CITY OF ALBUQUERQUE

March 16, 2018

RE: **Explore Academy**
5100 Masthead NE
Conceptual Grading and Drainage Plan
Engineer's Stamp Date 3/12/18
Hydrology File: D17D003N

INLET DETAIL

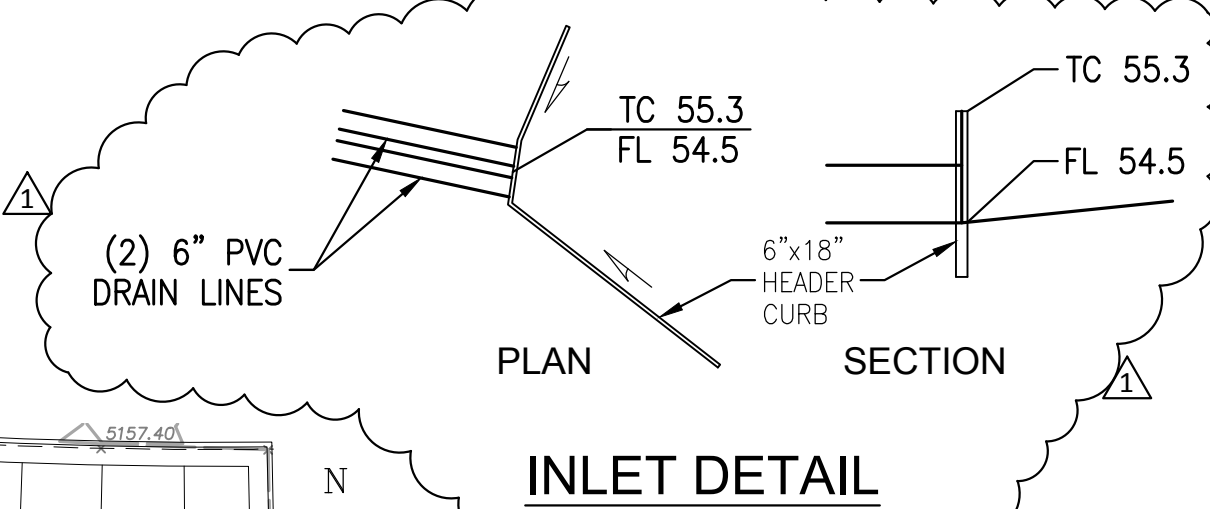
1. Provide a detail for the 6" pipe inlets. Will these have a concrete apron and end section? Will they be grated? Will there be a local depression to prevent bypass flows?
2. A Private Facility Drainage Covenant is required for the stormwater quality pond. The original notarized form, exhibit A (legible on 8.5x11 paper), and recording fee (\$25, payable to City of Albuquerque) must be turned into DRC (4th, Plaza del Sol) for routing. Please contact Charlotte LaBadie (clabadie@cabq.gov, 924-3996) or Madeline Carruthers (mtafoya@cabq.gov, 924-3997) regarding the routing and recording process for covenants.
3. Additional comments may be provided at Building Permit, based on the outcome of the above remarks and level of detail shown on plans.
